**RESPONSE TO SUBMISSIONS  
State Significant Development SSD-5746**

**Proposed Expansion of Existing Mainfreight Facility  
including Storage of Dangerous Goods (Chemical Storage Facility)**

**30-50 Yarrowa St, Prestons  
(Lots 101 & 102 DP 1117691 and Lot 2 DP 28729)**

**July 2013**

12.424	-	TX.03	1
project no.	drawing phase.	drawing no.	rev

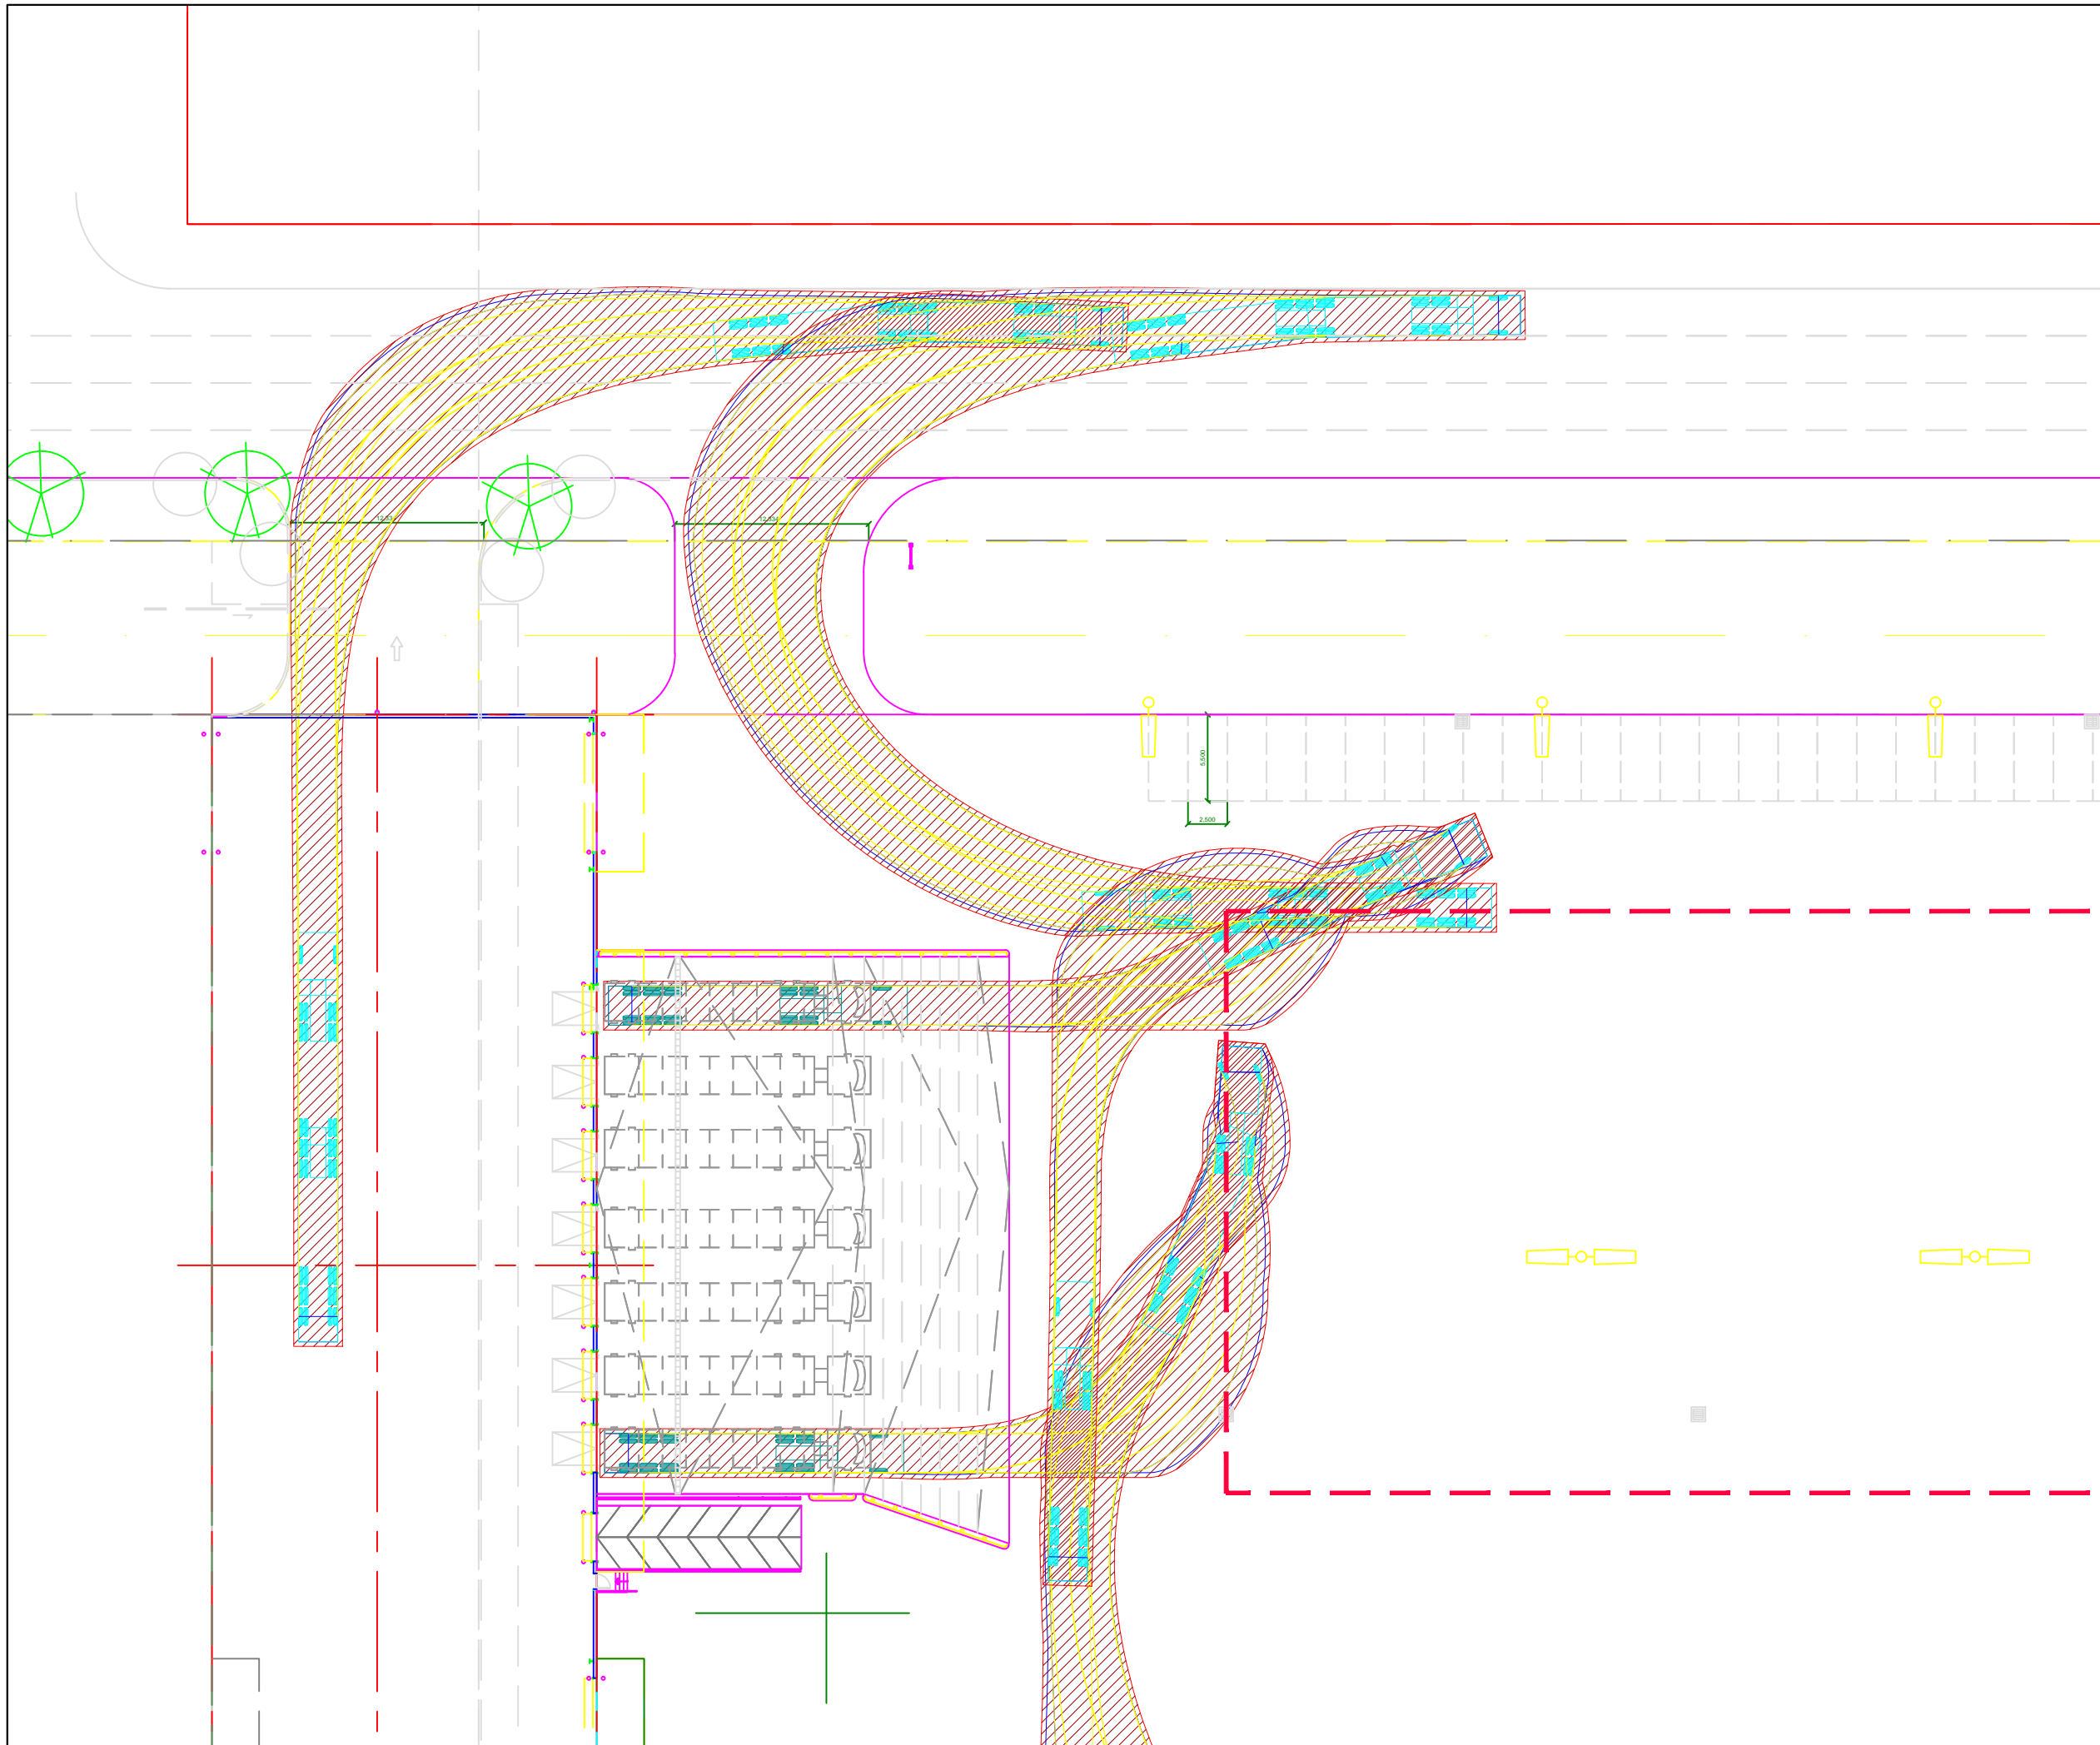
|          |               | Swept Path Drawing No. TX.03 appears to show a truck exiting the site using the existing driveway which is proposed to be located and reinstated.  | Transport, Traffic and Parking | Part C – Section 3.2 |
|          |               | Swept Path Drawing No. TX.03 shows trucks exiting the site only, while the architectural plans show this as a combined truck entry/exit point. Truck movements through this access point needs to be clarified, especially in light of the commitment given that no dangerous goods will transported through the TransGrid easement.   | Transport, Traffic and Parking | Part C – Section 3.2 |

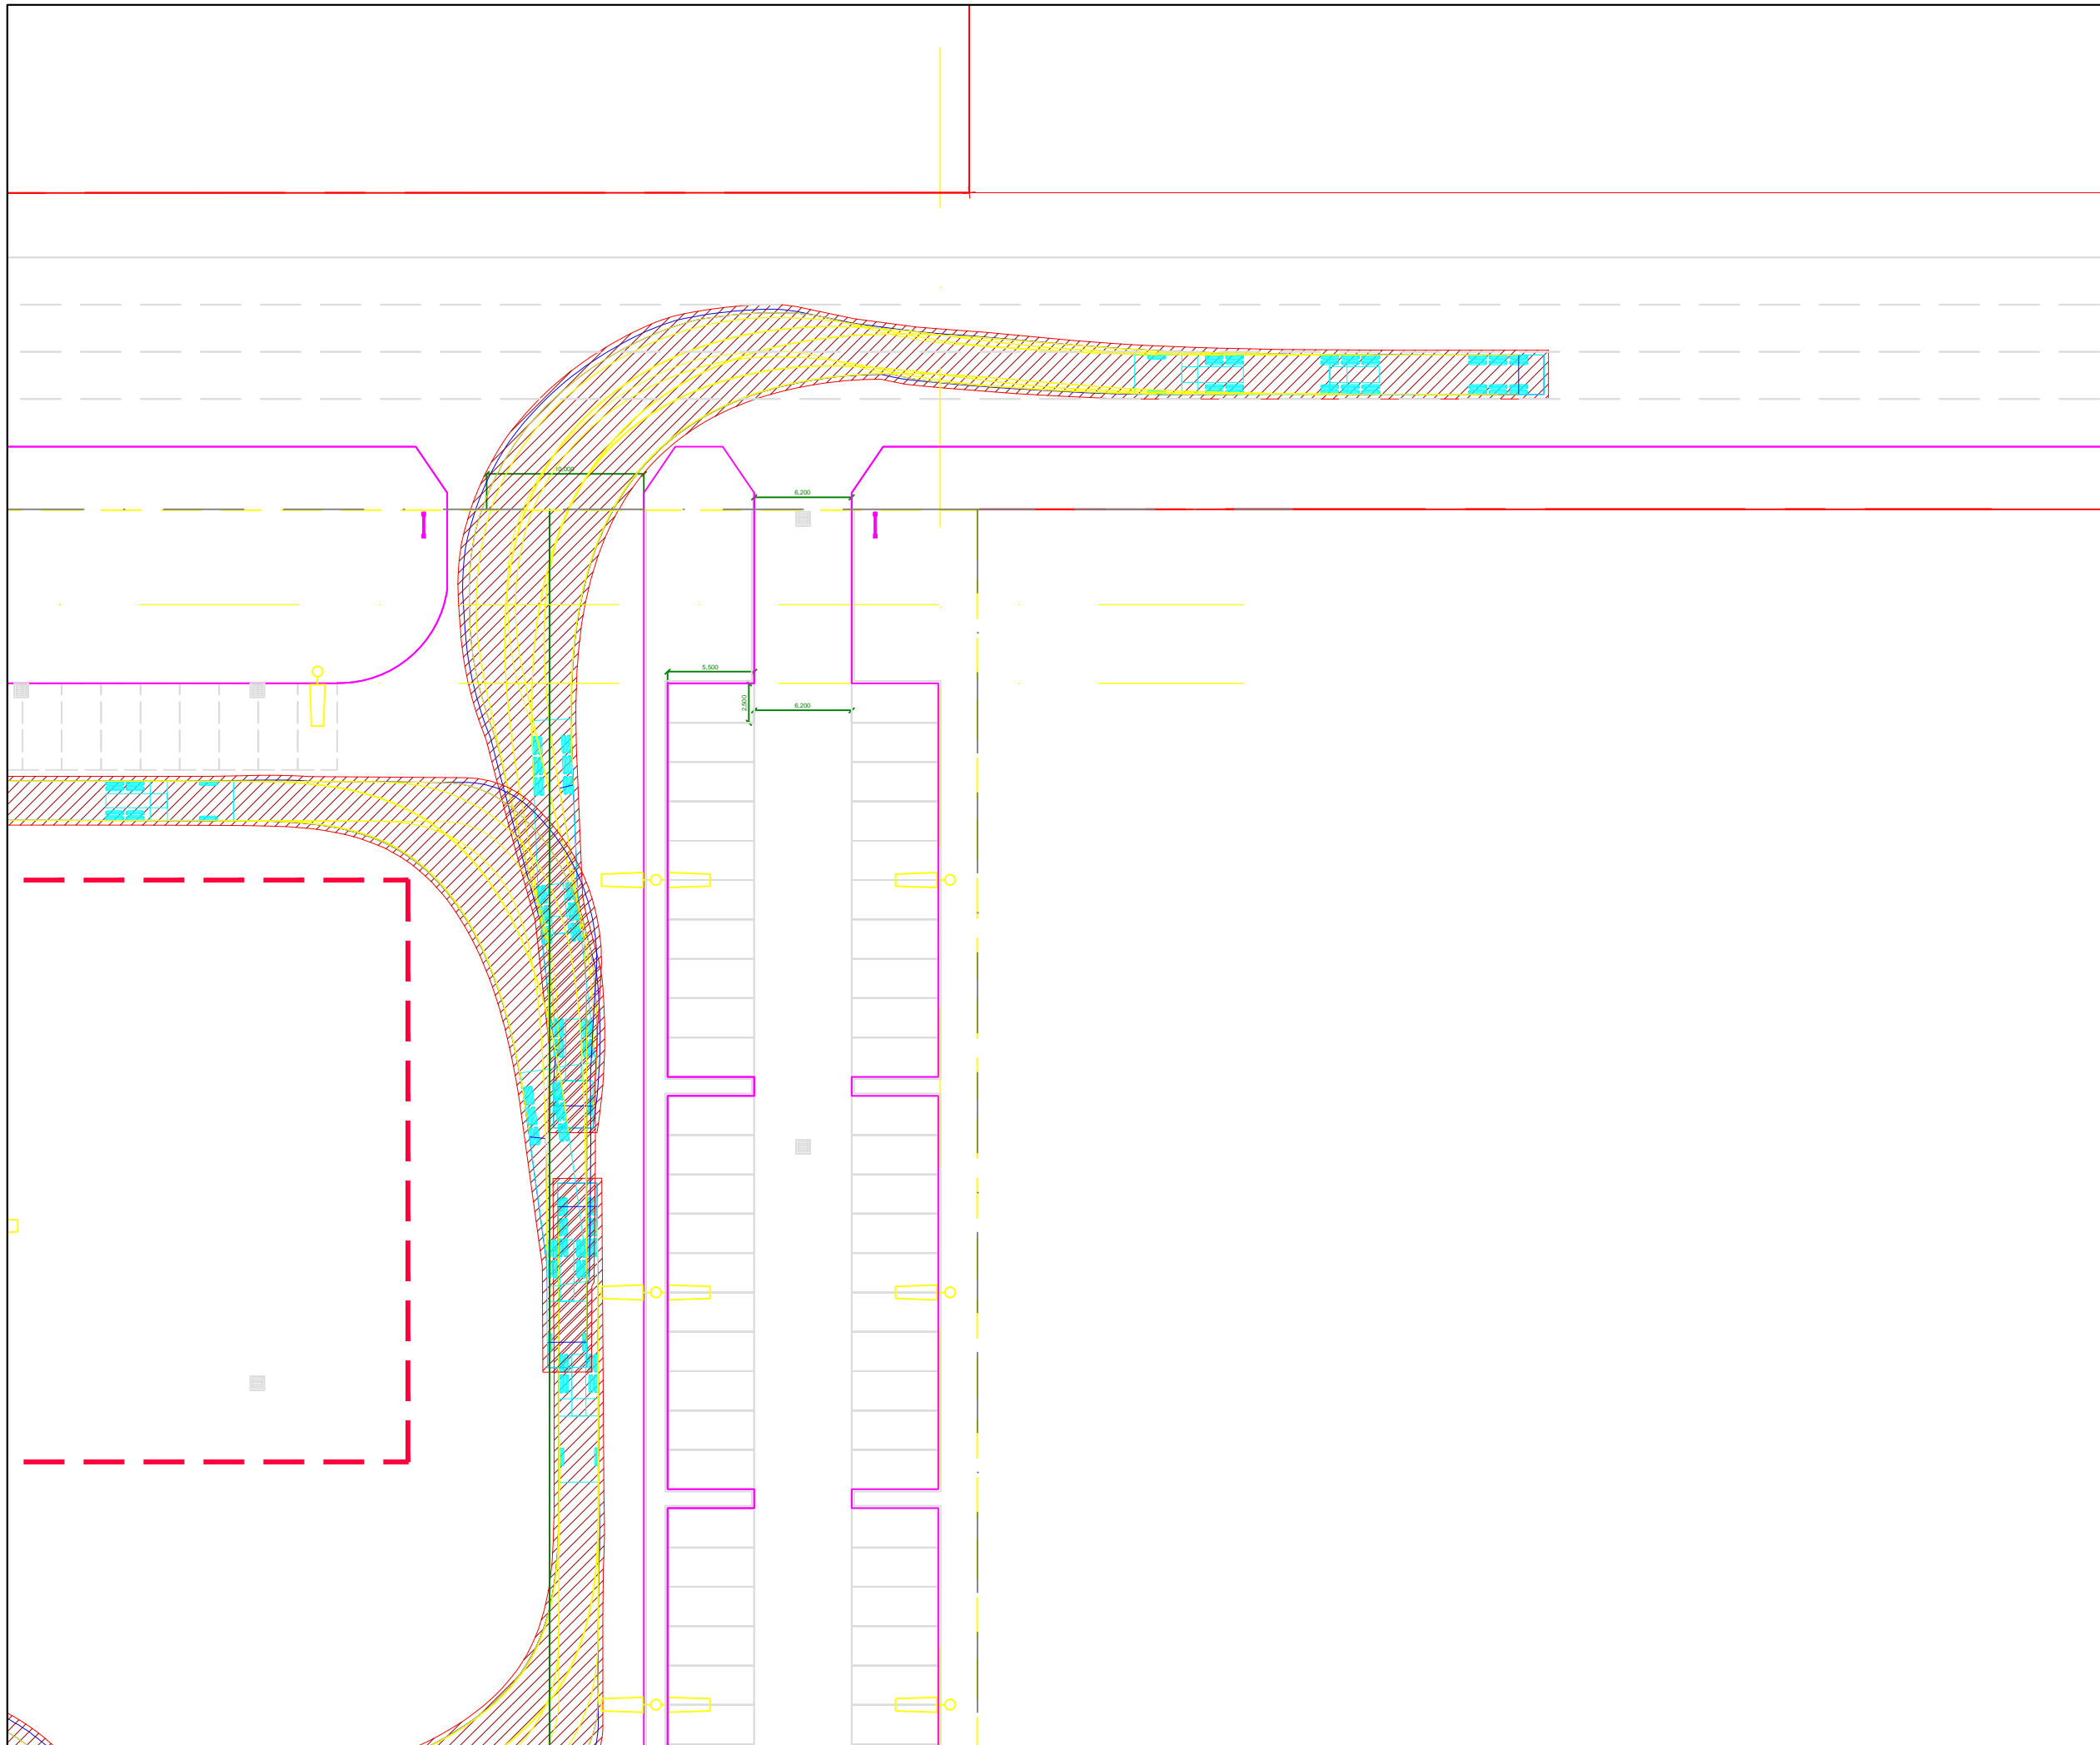
|          |               | Swept Path Drawing No. TX.04 shows trucks entering the site only, while the intersection is marked as a combined truck entry/exit point on the architectural plans.  | Transport, Traffic and Parking | Part C – Section 3.2 |
|          |               | Swept Path Drawing No. TX.04 shows that trucks entering the site cross the centre line of the road to access the site.   | Transport, Traffic and Parking | Part C – Section 3.2 |
